14th August 2018

Addendum 5 to Arboricultural Impact Assessment Report Art Gallery of NSW Expansion Project – Sydney Modern [SSD 14_6471].

I refer to the above matter and your request to review the revised drawings for the abovementioned development and assess the potential impact of the proposed works on T1118 (Port Jackson Fig). I also refer to the previous Arboricultural Impact Assessment Report prepared by Earthscape for the abovementioned Project [version 9 dated 3rd November 2017].

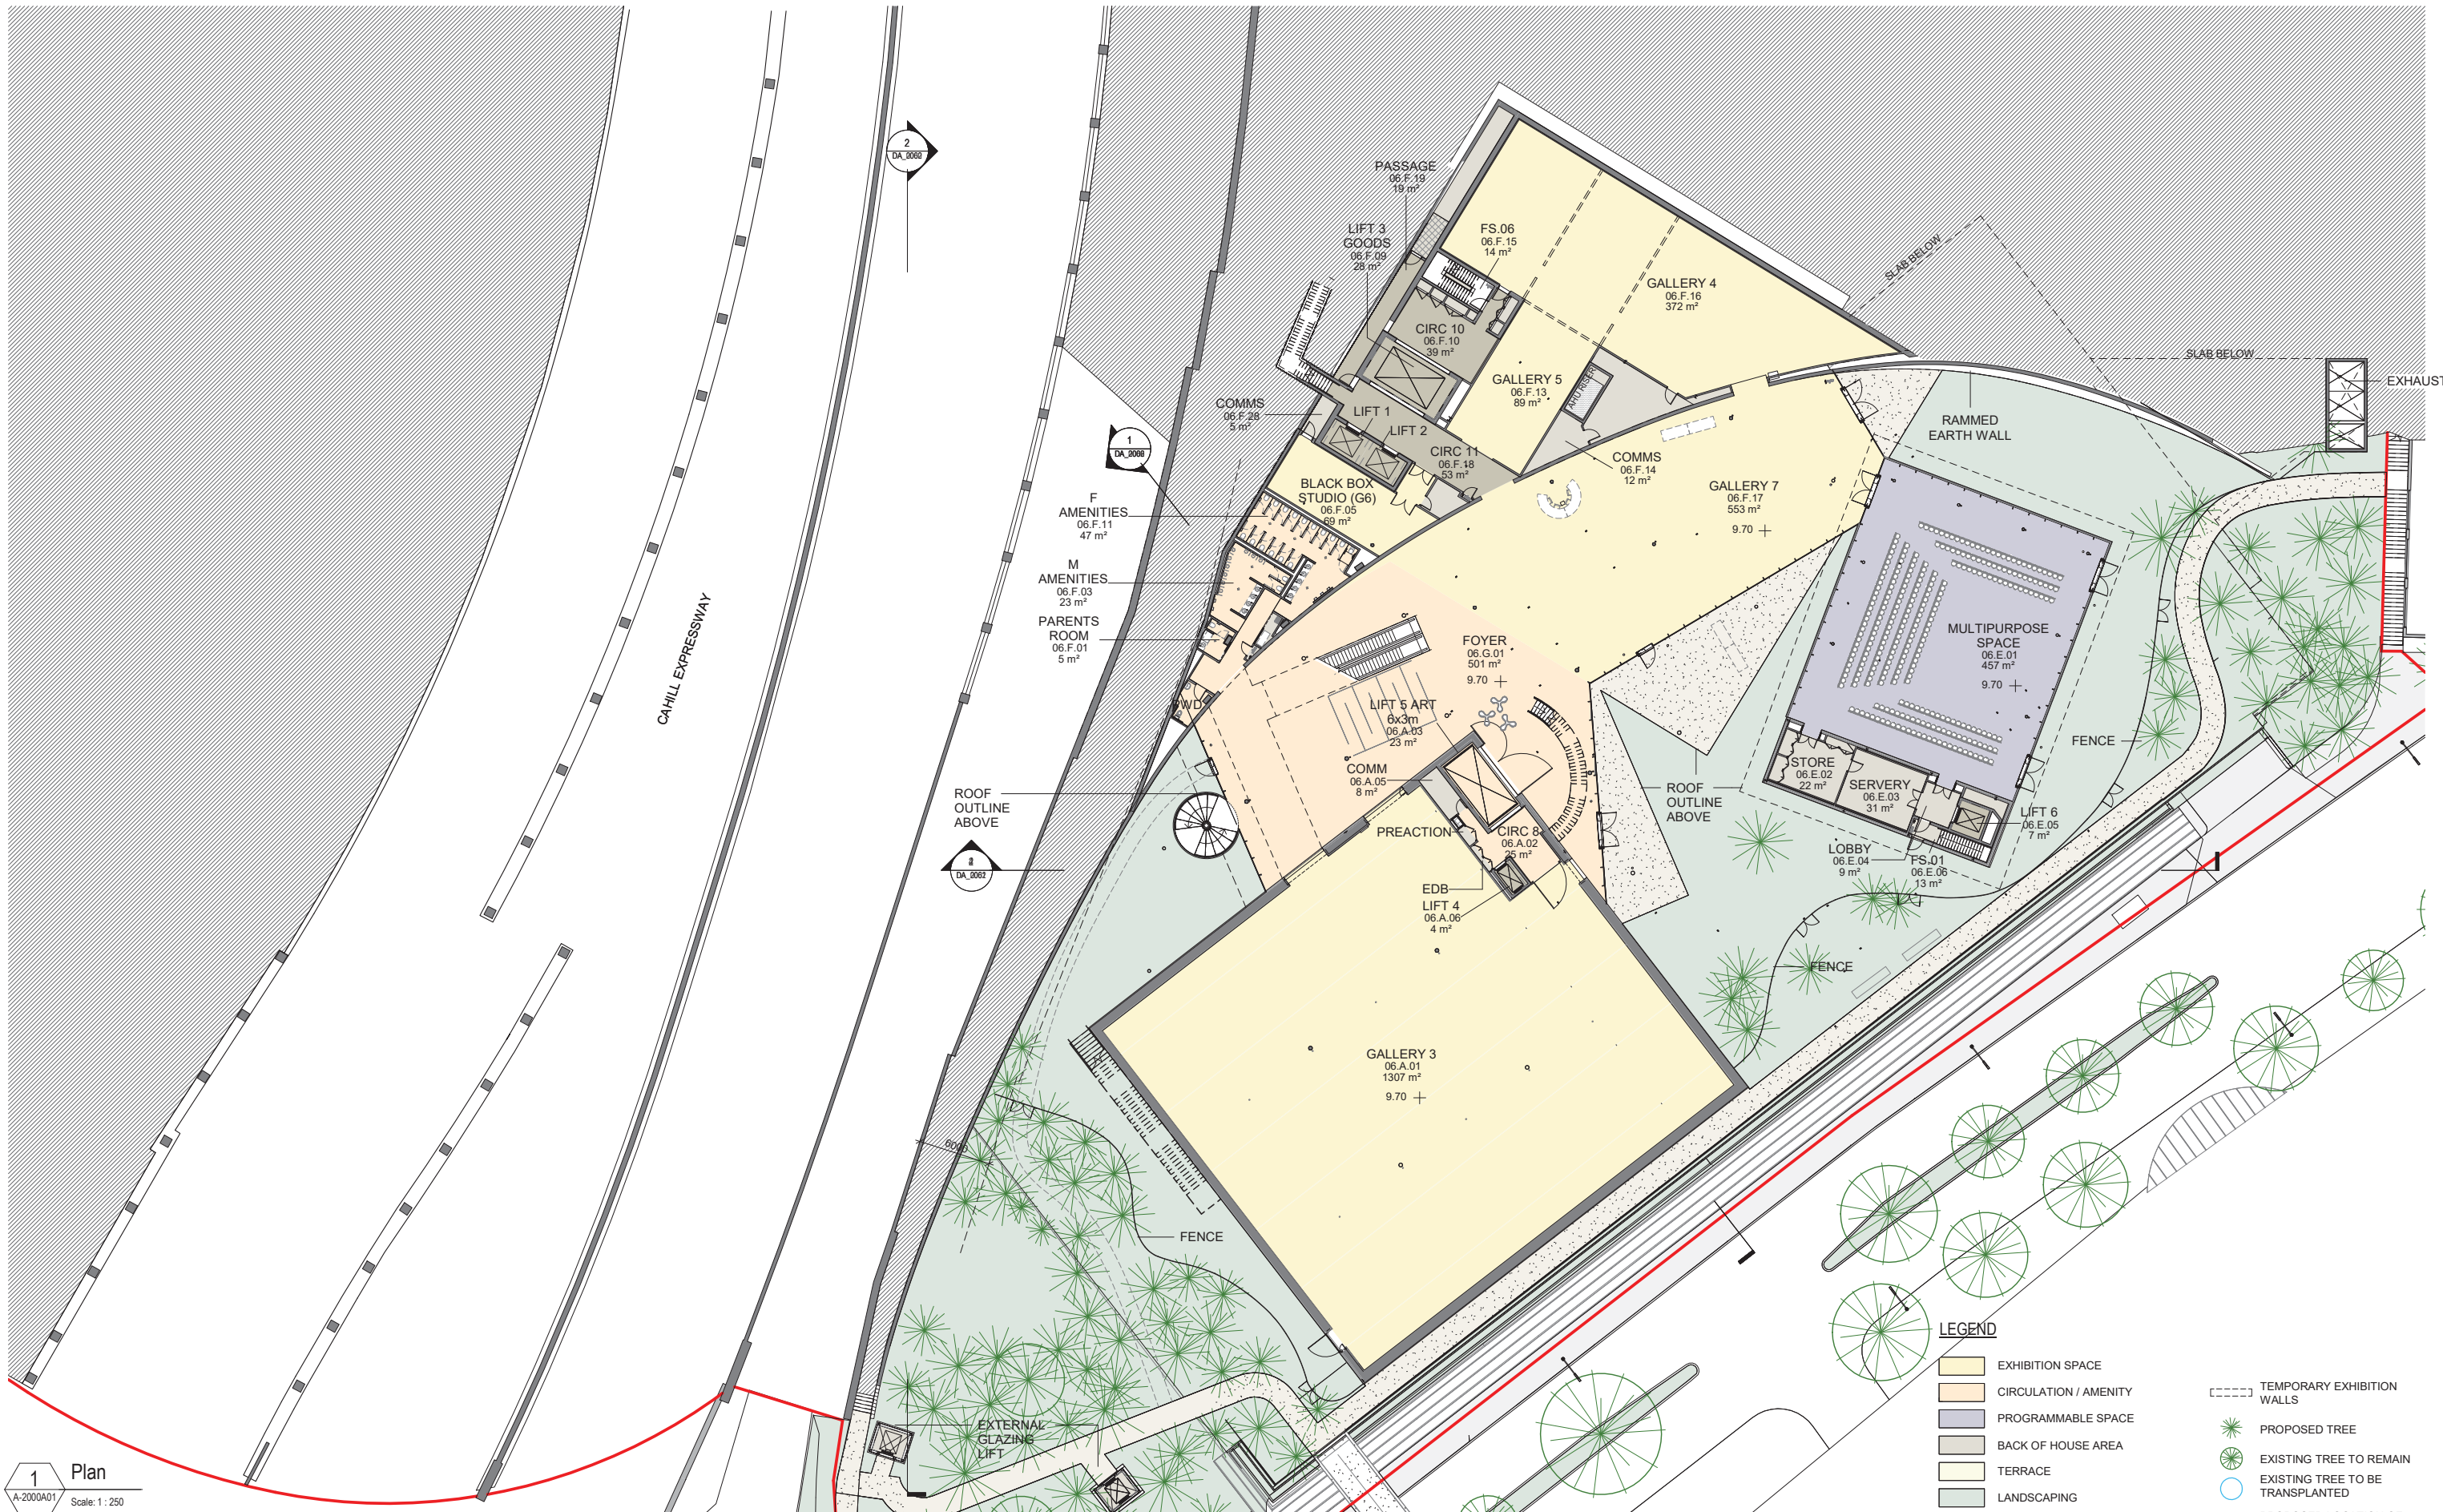
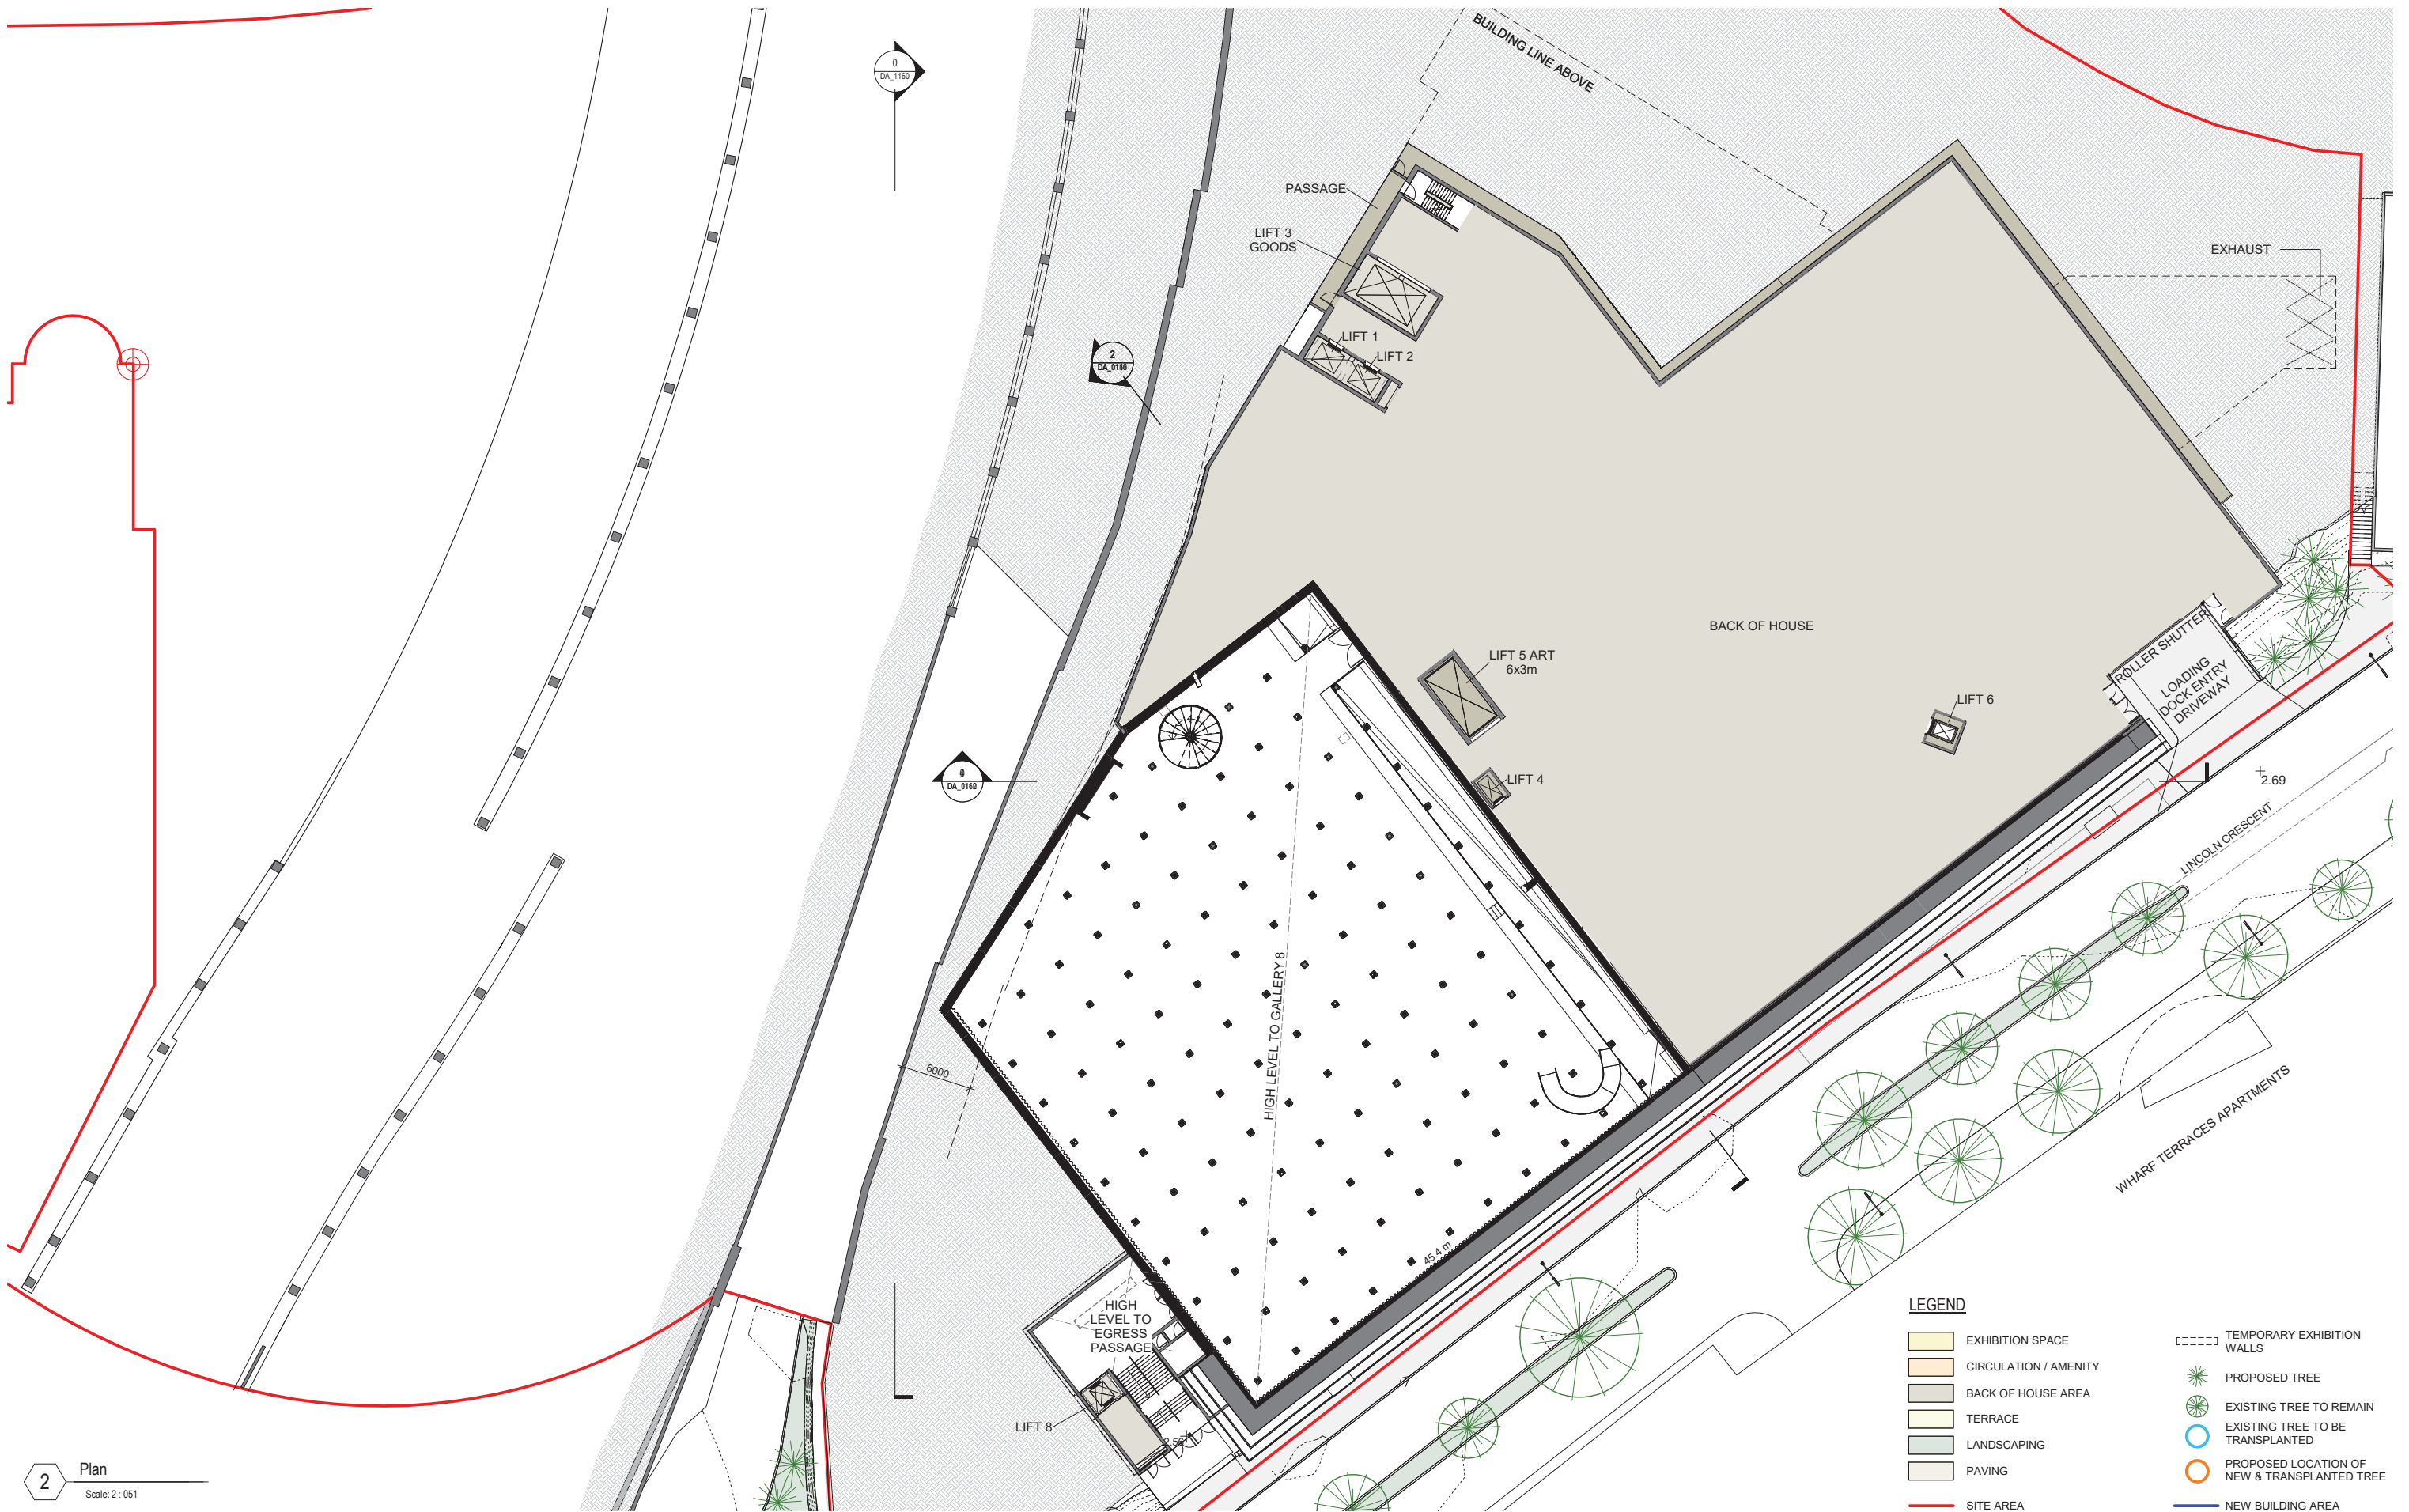
The Entry Level Plan prepared by Architectus [DA_1001 Rev M dated 06/08/2018] indicates proposed bicycle parking to the north-west of T1118 in what is assumed to be concrete pavement, whereas the SSDA landscape drawings indicated a widened pedestrian path constructed using decomposed granite. The original pathway was offset further from the tree and resulted in an encroachment to the TPZ of approximately 9%, whereas the new bicycle parking will result in an encroachment of approximately 12%.

Following preliminary review of the abovementioned drawings by Earthscape, revised drawings have now been prepared by ARUP and McGregor Coxall (Dwg No. LD_DA_00-17 [D] dated 13/08/2018) in an effort to reduce the extent of encroachment (see attached drawing). This has resulted in reduction in the width of the pile wall and the inspection space, reducing the encroachment on the south side of T1118 to just under 14% (based on the Earthscape calculation of the TPZ). The bicycle parking has now been relocated outside the TPZ and the existing asphalt path alongside Art Gallery Road will now be maintained intact at existing levels. As such, there will be no additional encroachment on the north-west side of the tree. Assuming that the calculation of the TPZ by BTC was used (13.56 metres radius), the estimated encroachment from the bulk excavation for the building and pile wall would be approximately 17%.

In my view this species will tolerate an encroachment of 17% of the TPZ, provided that all excavations for the pile wall are undertaken in accordance with Section 10.6 of the abovementioned Arboricultural Impact Assessment Report. It should be noted that ARUP has confirmed that no 'over-excavation' is required for this type of wall construction as assumed by BTC. As such, I confirm that in my view, the proposed revised layout will not result in any adverse impact on T1118.
